Item No. **Report of the Head of Planning, Transportation and Regeneration**

Address 33 BRAMBLE CLOSE HILLINGDON

Development: Erection of a single storey side extension involving demolition of existing detached garage.

LBH Ref Nos: **53061/APP/2022/1435**

REFERENCE NO:
22_11_33 Bramble close,
Uxbridge, UB8 3QE
DRAWING NO: SW/PLN/21103

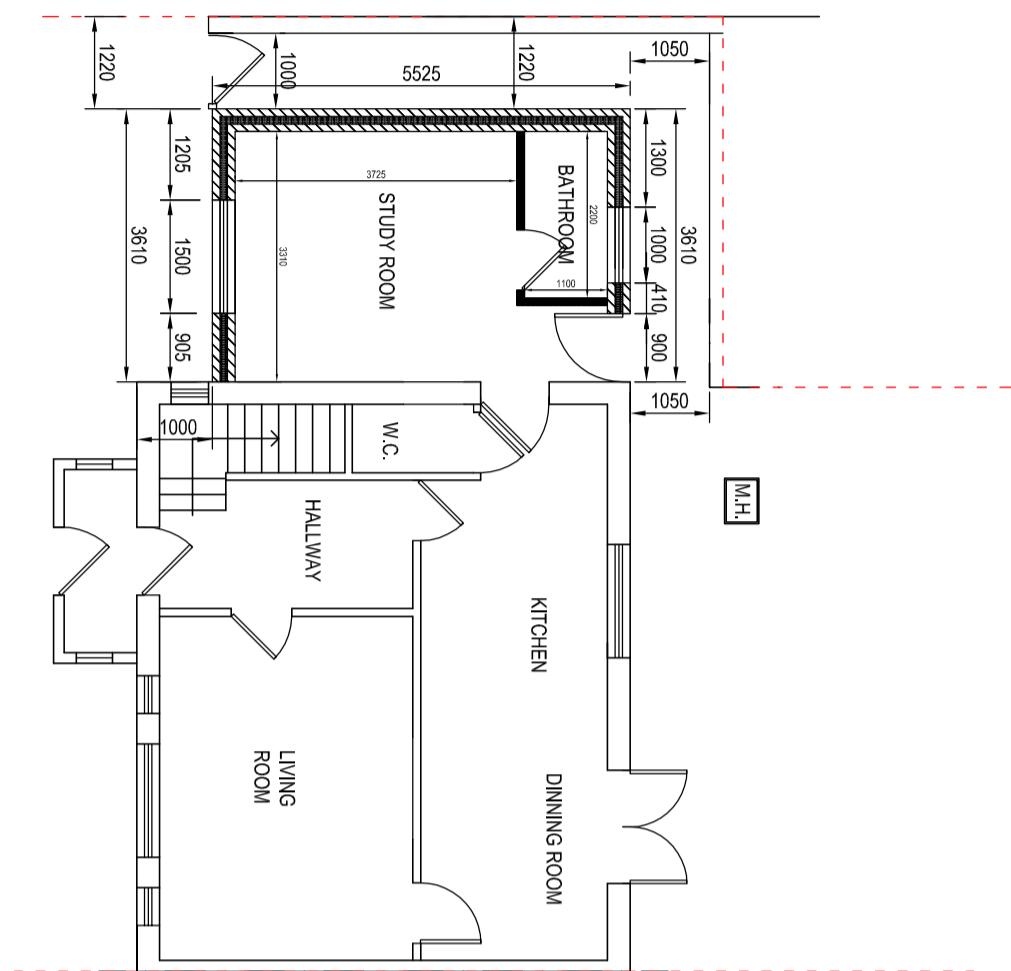
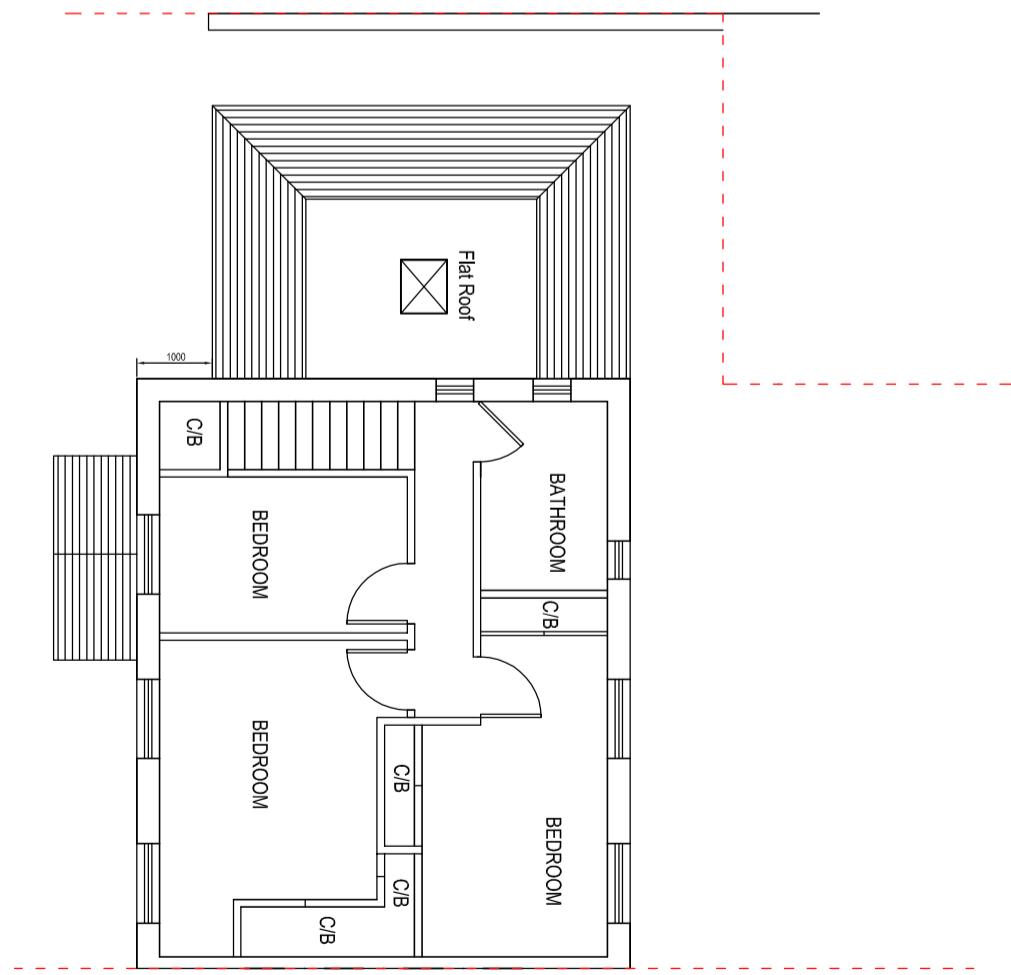
The side extension is proposed to be set back from the front elevation by 1m and extends from the northern side elevation of the dwelling by 3.6 metres, for the full length of the dwelling. It will have a small crown roof but this is considered to be appropriate given that it serves a small side extension and the design would relate to the original dwelling. A 1 metre gap will be retained to the northern boundary for access into the rear garden, this access path would wrap around the rear of the extension into the garden. A brick wall would be built to the utmost boundary for privacy into the curtilage of the site. The width is acceptable given the existing garage to be demolished at the site.

The side extension would be built away from the side of this neighbour and would not impact the outlook, daylight or amenity of this neighbour.

The rear wall of the side extension would be built 16 metres to the east of this neighbour. Given the positioning, distance and appropriate size of the side extension, there will be no unduly detrimental impact created for this neighbour and is considered to be acceptable development.

This neighbour is built 15 metres to the north of the application site. The proposal would not create any additional bulk which is not already existing and as such would not impact the amenity of this neighbour in any way, given the distance and existing arrangement.

REFERENCE NO:
22_11_33 Bramble close,
Uxbridge, UB8 3QE
DRAWING NO: SW/PLN/21104

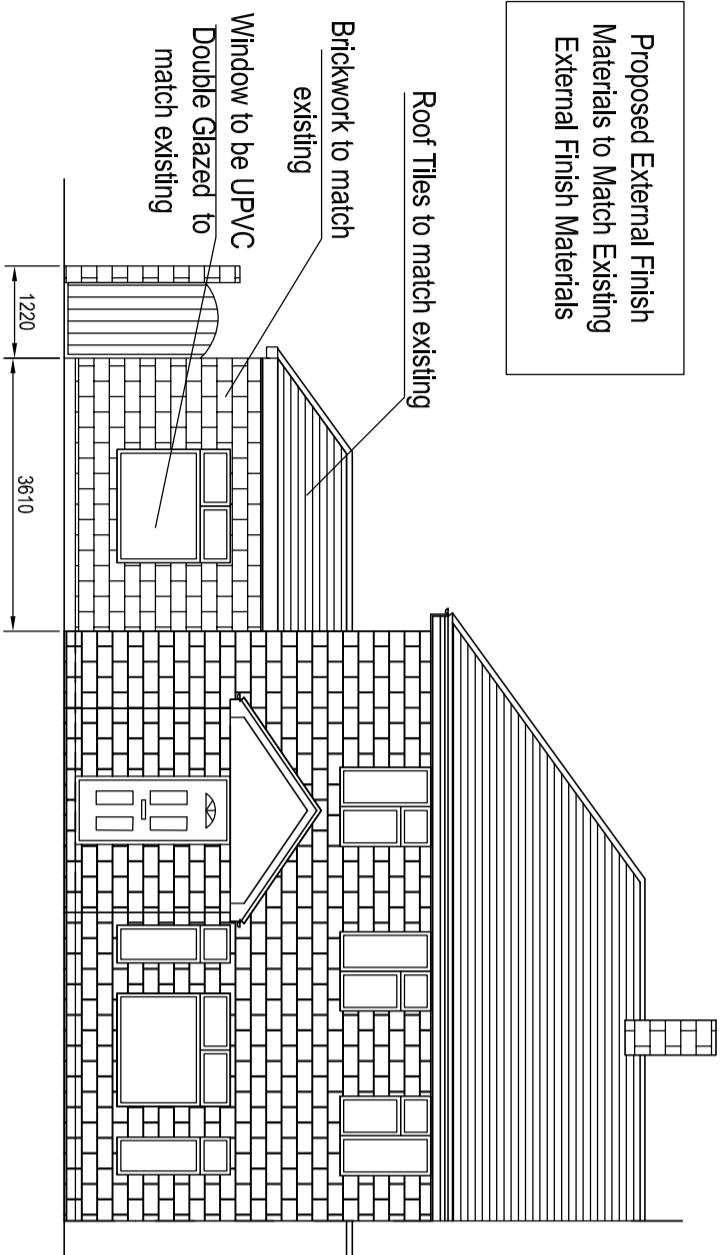
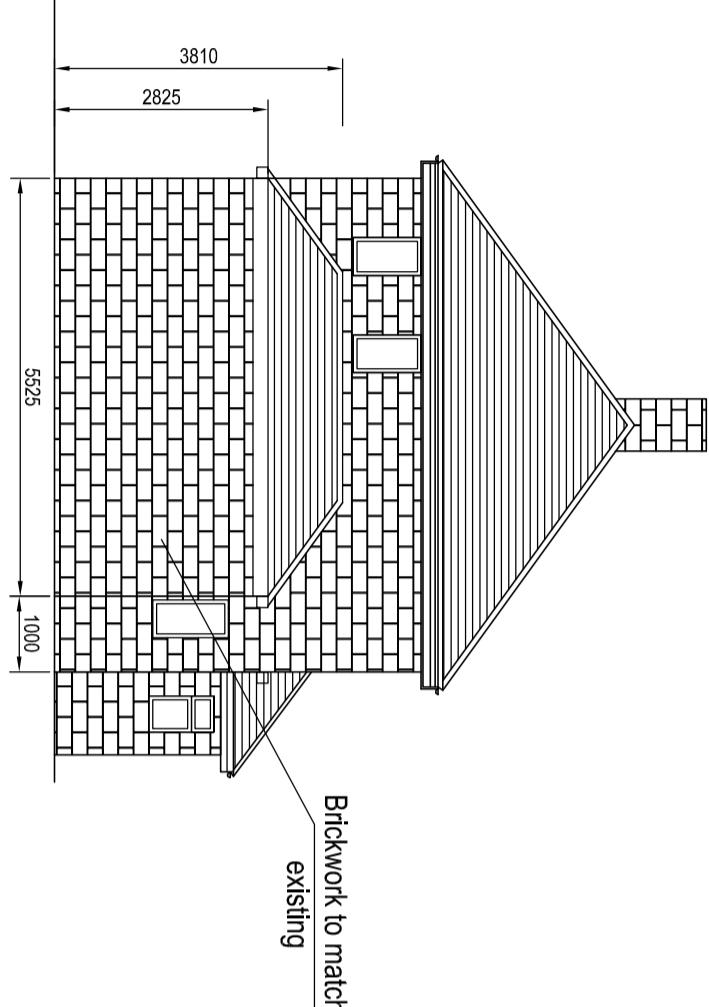
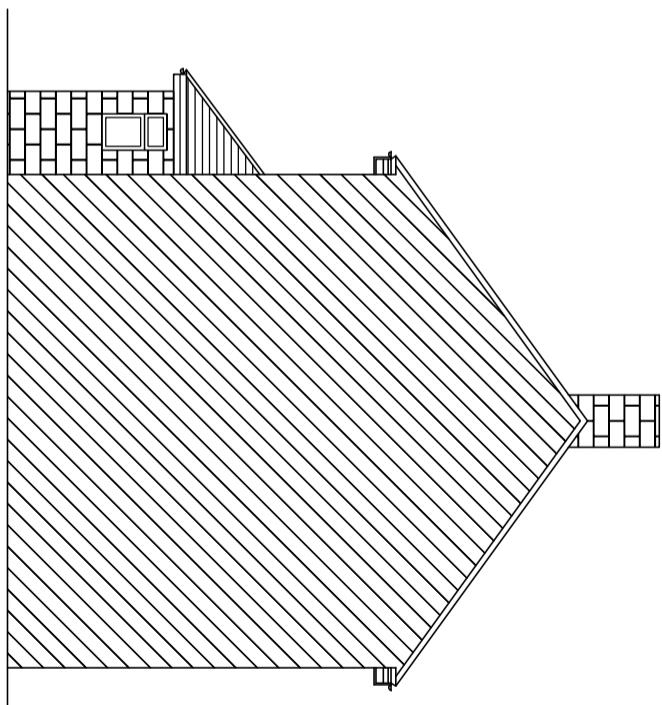
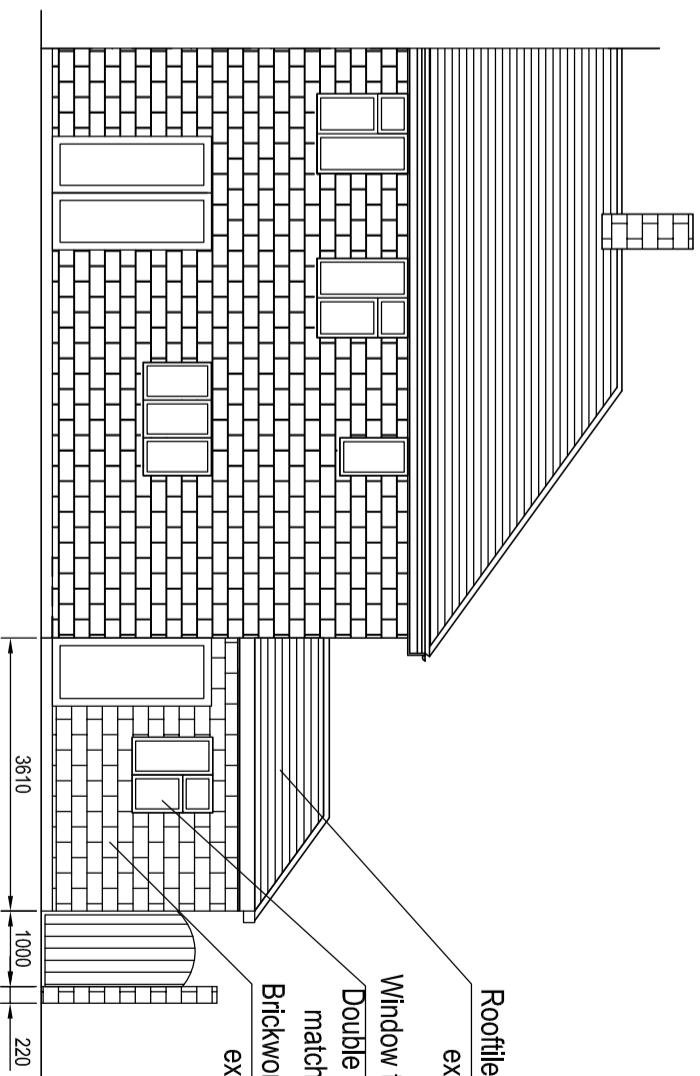
No. 35 appears to have a flat roofed side extension at the end of the Close, there is no planning history related to this. Cumulatively, the pair of semi-detached dwellings would both have side extensions which would balance the bulk of the dwellings, although the design would be different. There are also other examples of side extensions on the street scene so the proposal would not be out of character.

Overall the scale and size of the side extension will retain a subordinate outlook to the dwelling and would not result in a harmful visual impact on the locality, in compliance with Policy DMHD 1 and DMHB 11.

The materials to be used in the construction of the external surfaces of the development hereby permitted shall match those used in the existing building and shall thereafter be retained as such.

Notwithstanding the provisions of the Town and Country Planning (General Permitted Development) Order 2015 (as amended) (or any order revoking and re-enacting that Order with or without modification), no additional windows, doors or other openings shall be constructed in the walls of the development hereby approved facing No. 7 Bramble Close.

Access to the flat roof over the extension hereby approved shall be for maintenance or emergency purposes only and the flat roof shall not be used as a roof garden, terrace, balcony, patio or similar amenity area.
